Road Safety Audit: Stage 1

**Formation of temporary construction access track
A629 Penistone Road, Birds Edge**

Plough Barn, Birds Edge Lane, Huddersfield

Produced for: Kirklees Council
Report Dated: 15 September 2026
Report Reference: RSA/ENG/170926

DRAWING TITLE
 2D Topographical Survey

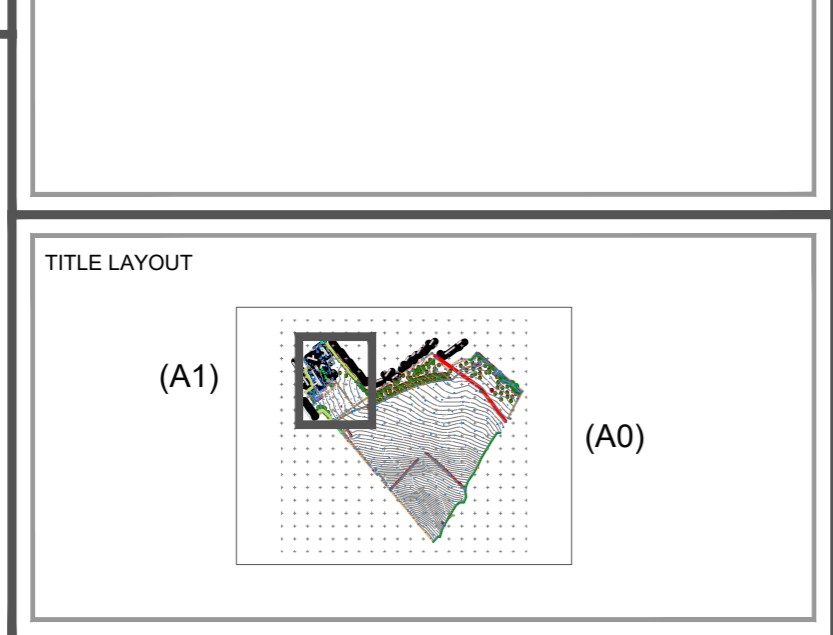
Visibility to the southeast of the proposed temporary access junction appears to be restricted due to sight-line obstruction caused by the existing hedge and trees, as illustrated in Photo 1. Such reduced visibility may increase the risk of drivers emerging from the construction access failing to adequately observe approaching north-westbound traffic, and vice versa, potentially resulting in give-way-type conflicts. Photo 2 shows the existing visibility splay to the northwest of the site entrance.

Furthermore, the visibility splay shown on the submitted plan has been measured from within the footway, which is incorrect, as the correct 2.4 metre x-distance would place the driver's eye position inside the site access. The width of the footway varies on either side of the entrance—approximately 2.0 metres on the north-western side and 1.7 metres on the south-eastern side—meaning that measuring the splay from within the footway does not represent the appropriate driver position.

A cast iron gully is present on the highway as shown in photo 5 below. Due to the proposed widening of the access the gully will be within the mouth of the junction and is likely to be overrun by construction site traffic. This may increase the risk of structural failure of the gully if not suitably constructed to withstand the loading associated with heavy vehicle overrun.

Vegetation within the visibility splay should be cut back and maintained to ensure adequate sight lines are provided at the junction. The visibility splay should be re-drawn and assessed from a set-back position of 2.4 metres from the back of the kerb line, to avoid any encroachment into the running carriageway

The gully should be repositioned outside the mouth of the junction as part of the works or reinstalled using a construction and cover that provides skid-resistance performance complementary to the adjacent carriageway surface.
